# BUILDING PERMIT

Located At 276 WOODFORD ST

Job ID: 2012-09-4873-CH OF USE

has permission to COU, 1st fl left to Sandwich shop, dwellings above  
provided that the person or persons, firm or corporation accepting this permit shall comply with all of the provisions of the Statutes of Maine and of the Ordinances of the City of Portland regulating the construction, maintenance and use of the buildings and structures, and of the application on file in the department.

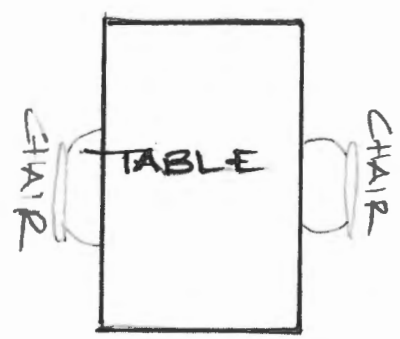
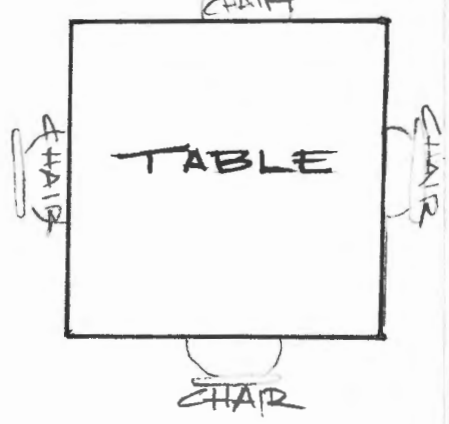
7. The proposed range/oven requires a separate permit for a commercial hood exhaust/suppression system per NFPA 96. As discussed, if an alternate appliance is installed the specifications shall be submitted to determine if a hood is required.

1. The building shall comply with City Code Chapter 10 upon inspection.
2. The floor plans do not indicate adjacent spaces, separations, or egress arrangement. This building is a multiple occupancy building with 3 dwelling units above the nonresidential occupancy. Per NFPA 101:31.1.2.3 **the dwelling units and exits therefrom must be**

**separated from the nonresidential occupancy(s) by 1-hour construction and fire doors or the nonresidential occupancy(s) must be protected throughout by an approved, supervised automatic sprinkler system.**
